SCHOLZ / ORCUTT:

Markup Summary

SCHOLZ/BOERTS

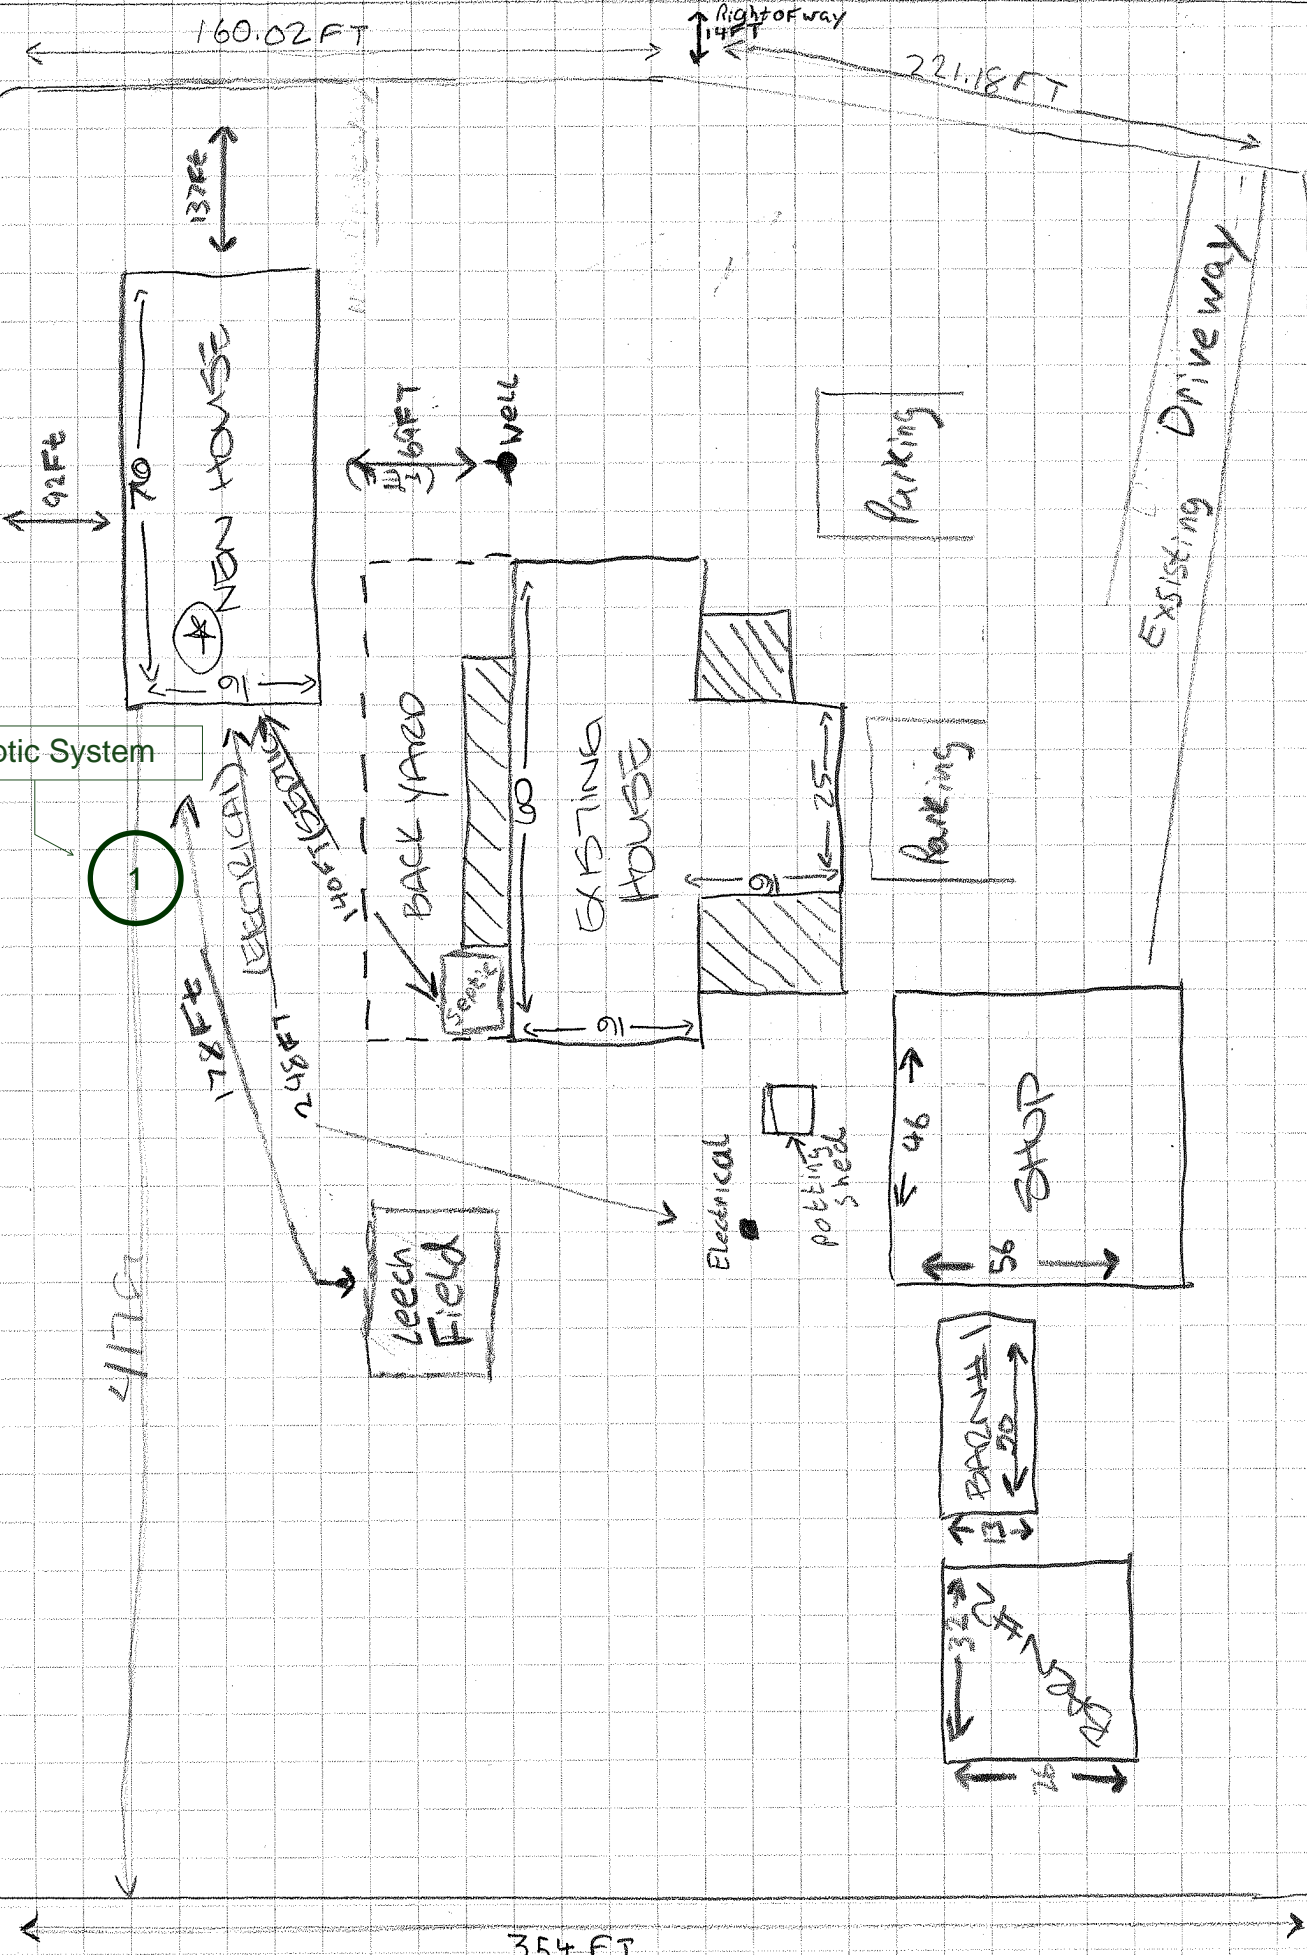
A North Arrow should be included to show where north is in relation to the plot.

Show connections to well, septic, electric meter.

Is This something?

A New Driveway Permit will need to be applied for if proposing a new access to Russel Drive.

distance to property line
